# CITY OF ALBUQUERQUE

June 23, 2015

**RE: Signal Pointe Subdivision  
Lots 19 & 20, Block 4, Tract 3, Unit 3, North Albuquerque Acres  
Grading and Drainage Plan, Engineer's Stamp Date: 6/14/15 (C20D070)**

CMU RETAINING WALL / SCOUR WALL SECT. A

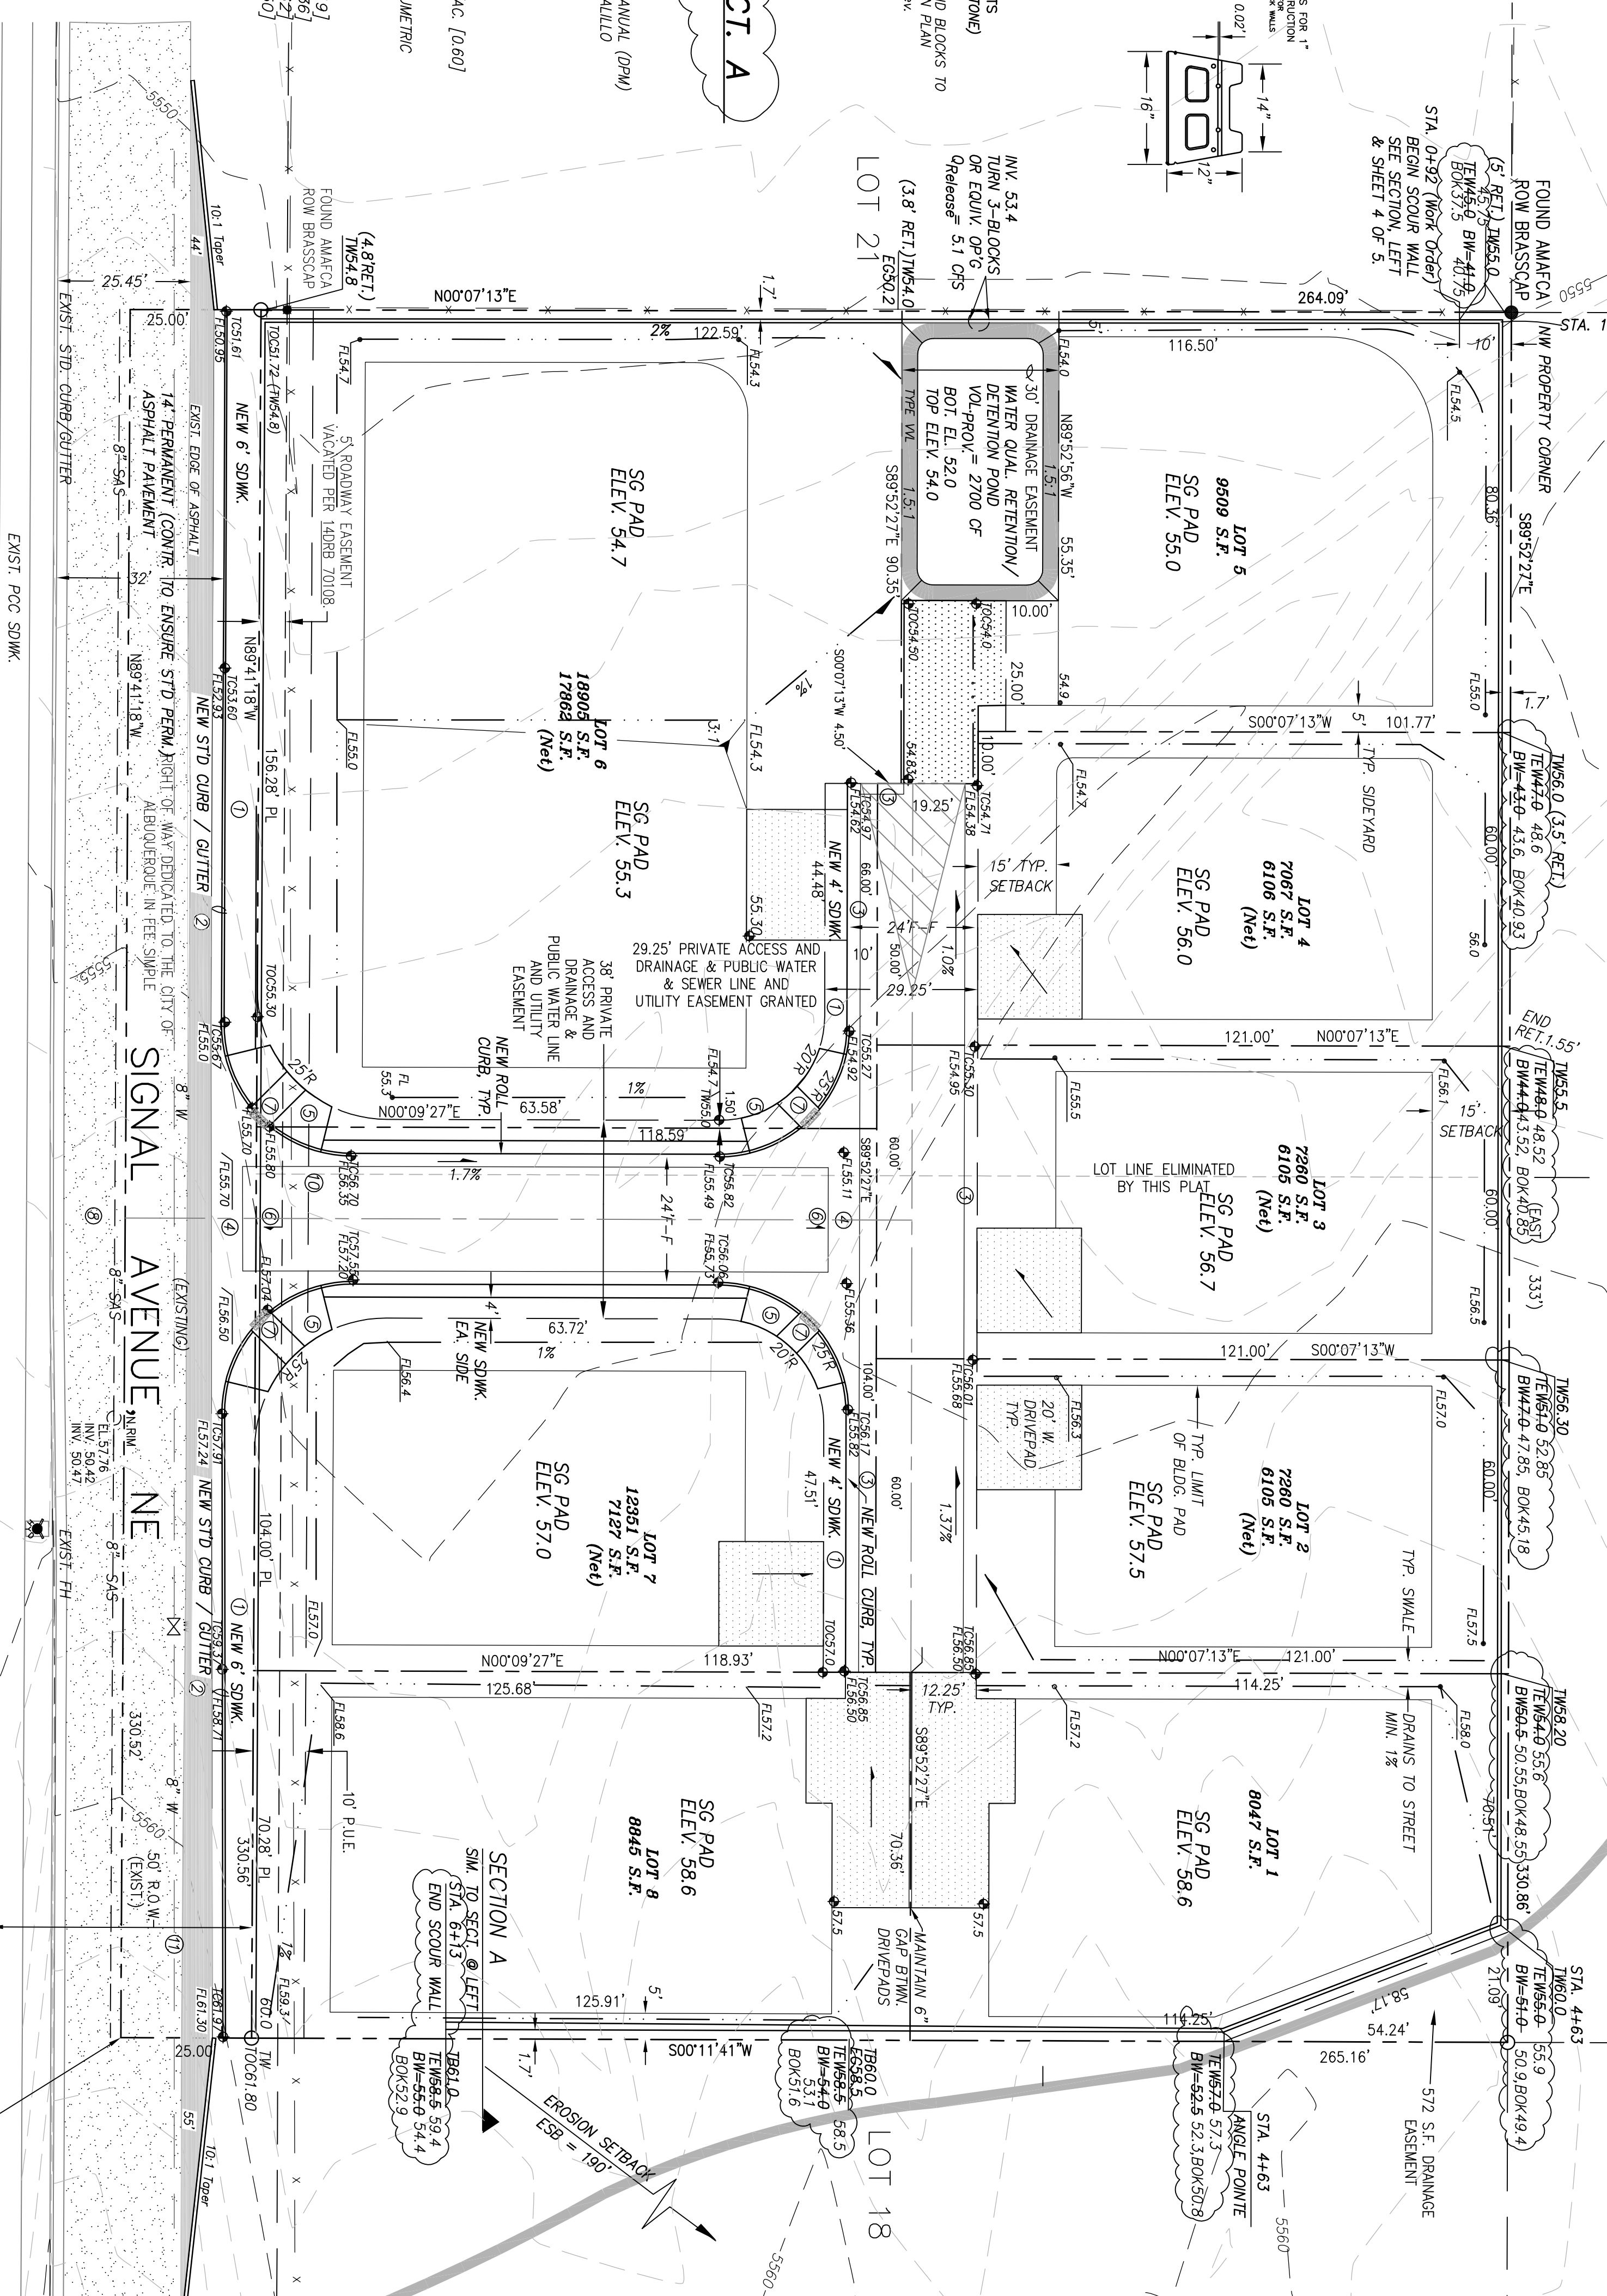
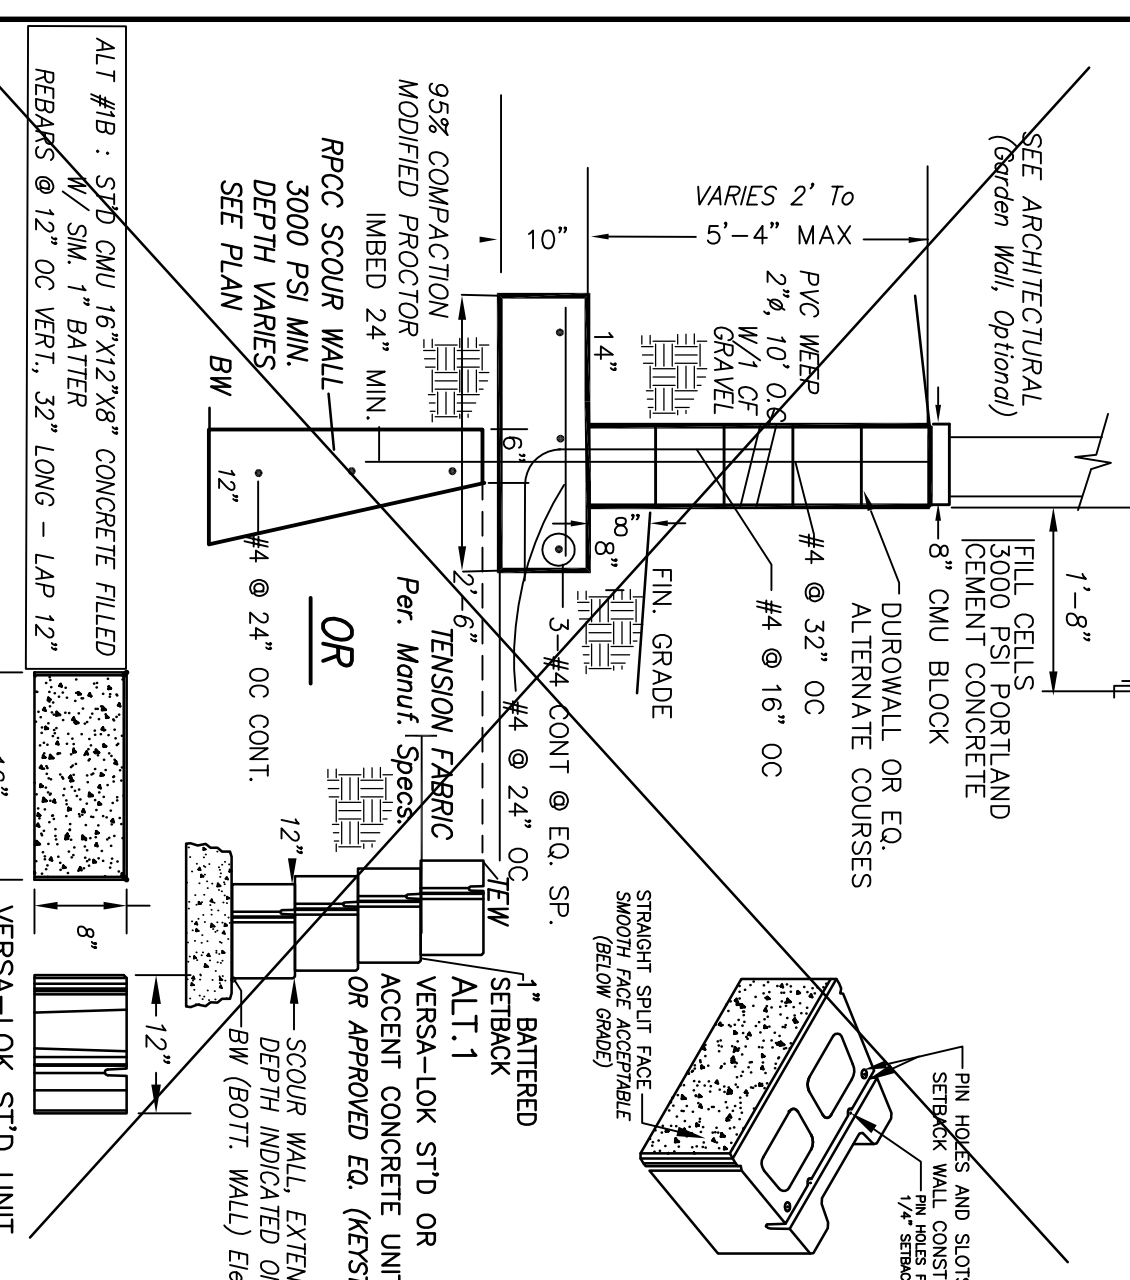
1. AMAFCA's approval is required for discharging through Lot 21 to the west of the project.
2. The wall should remain in place once the erosion occurs. Please design the flood control structures accordingly. The top of the footing for the proposed retaining wall must be at the scour depth. Proposed flood control structure proposed for the east side of the project will not remain in place once the scour occurs. A retaining wall or another form of structure must be used which would remain in place once erosion occurs.

3. Bottom of the wall or top of footing for the flood control structure must be at 51.0 along the east side of the project (within the erosion setback). Plan and Profile with details for the flood control structures should be submitted with DRC plans.

5. The Q-Release shown on the west of turned blocks is 5.10 cfs. Is the discharge at 1.80 cfs?
6. The invert of the turned blocks is at 51.40. The orifice equation used shown on the plan indicates that  $H=2.0'$ . Therefore, the water surface elevation is designed to be at 53.40'. Based on this elevation the runoff will be backing up into lots 5 and 6.

7. The drainage easement must be only on one lot (proposed Lot 5 or Lot 6). Maintenance responsibility of the pond should be noted on the plat.
8. Based on the latest calculations 22% of the 3090 cfs (680 cfs) will flow towards the easterly wall. Provide analysis that the runoff will not overtop the flood control structure, and that it will be able to drain north once it reaches the wall. How will this impact the flood control structure? Does it have to be extended to the south?
